**WELWYN HATFIELD BOROUGH COUNCIL – DEVELOPMENT MANAGEMENT**  
**DELEGATED REPORT**

**APPLICATION No:** S6/2014/1365/FP

**SITE ADDRESS:** 391 St Albans Road West, Hatfield

**DESCRIPTION OF DEVELOPMENT:** Erection of first floor extension and new window to side elevation

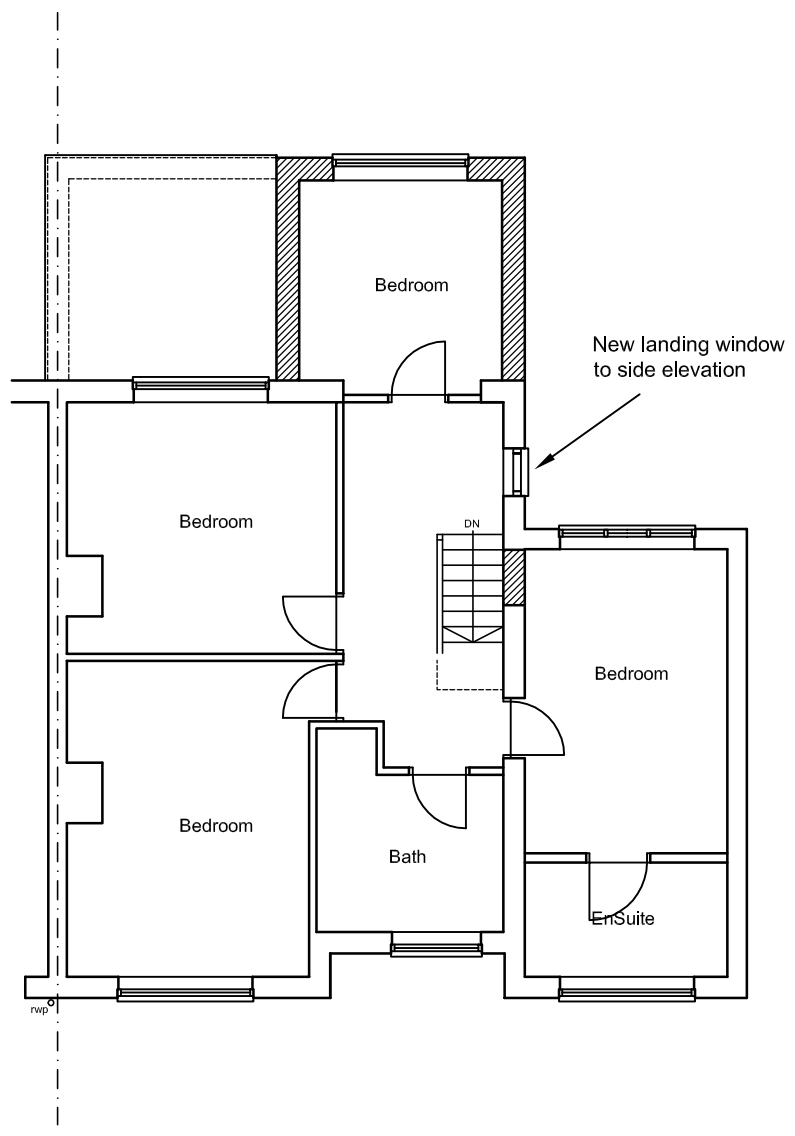
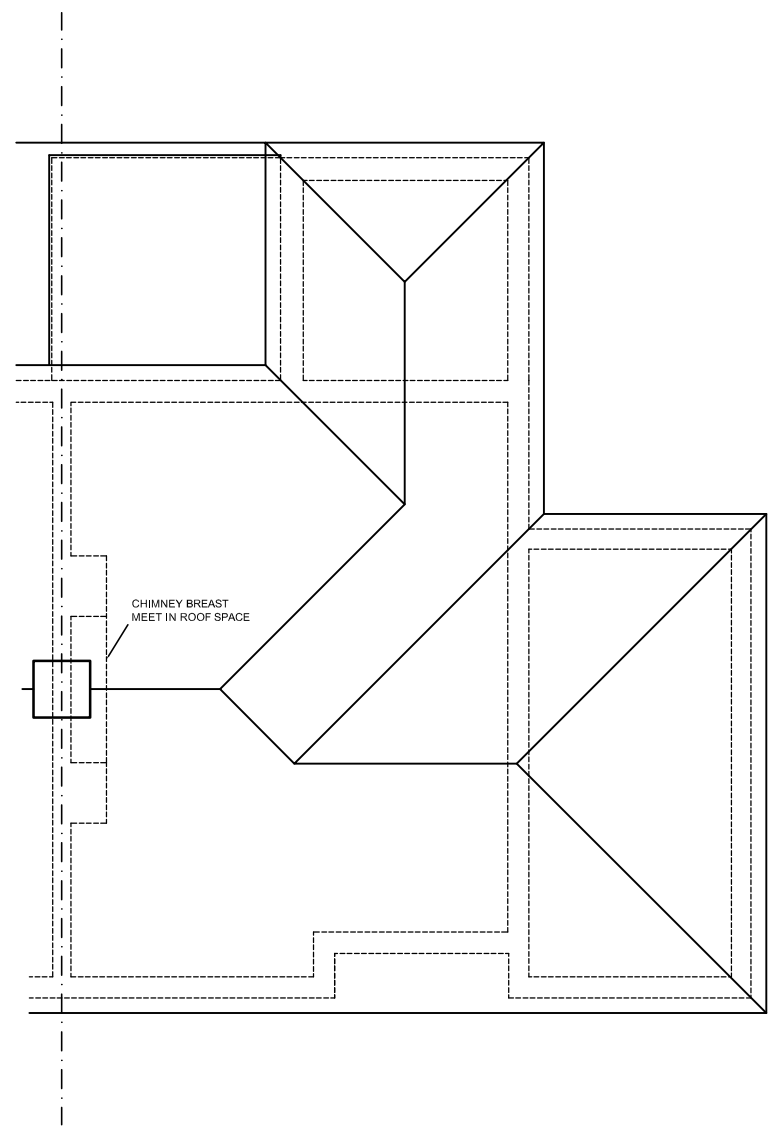
This application seeks full planning permission for the construction of a first floor extension. The extension would have a maximum height of approximately 6.1m, an eaves height of 4.9m, a width of 3.6m and would extend beyond the rear wall of the application property by approximately 3.2m. Proposals also include a new first floor window on the western elevation of the application property.

Having regard to the build, form and positioning of the proposed extension in relation to rear habitable room windows in neighbouring properties nos. 389 & 393 St Albans Road West, it is considered that this aspect of the proposal would not result in significant levels of harm to neighbouring amenity, in terms of overbearing and loss of light. Furthermore, as there would be no side facing windows within this extension and the proposed first floor rear window would not afford direct views of primary neighbouring amenity space, it is also considered that the proposed extension would preserve neighbouring privacy.

Drg.No: AT502-05

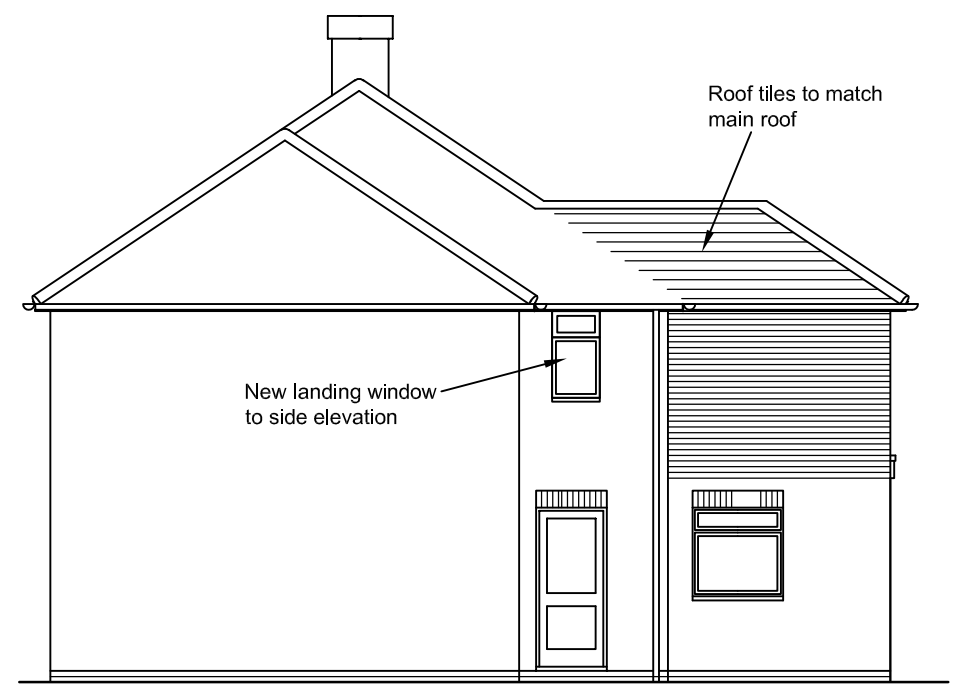
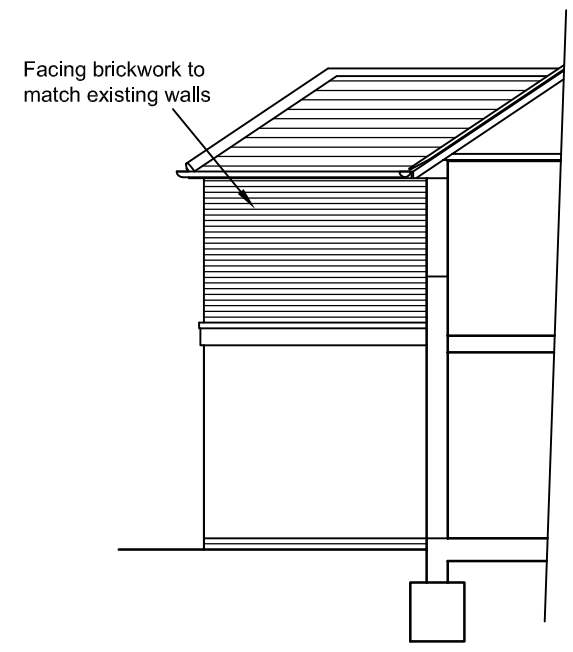
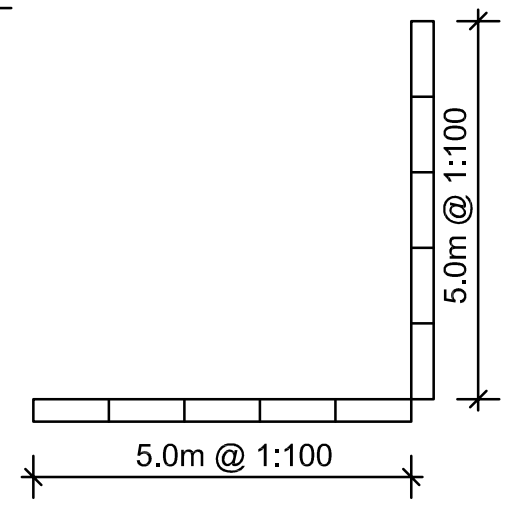
As the proposed extension is to the rear of the application property, views of this aspect of the works would be limited from the public domain. There would, however, be views of the proposed additional window on the side elevation of the host dwelling from certain vantage points along the access road. The extension remains subordinate in height and width to the host dwelling and would be constructed of materials to match those of the application property. Having regard to this, and as the proposed window on the western elevation of the application property would make no discernible change to the overall design of the host dwelling, it is considered that the proposed development would not disrupt the design and character of the existing dwelling. Having regard to the above, it is also considered that the proposal would not disrupt the character and appearance of the immediate streetscene and the visual interests of its surroundings.

Additionally, it would appear that a first floor window in the eastern elevation of the adjacent dwelling no. 393 St Albans Road West serves a non-habitable room. Having regard to this, and as the proposed window to the western elevation of the application property would not serve a habitable room, it is considered that this element of the proposal would not significantly and demonstrably harm neighbouring amenity in terms of overlooking.
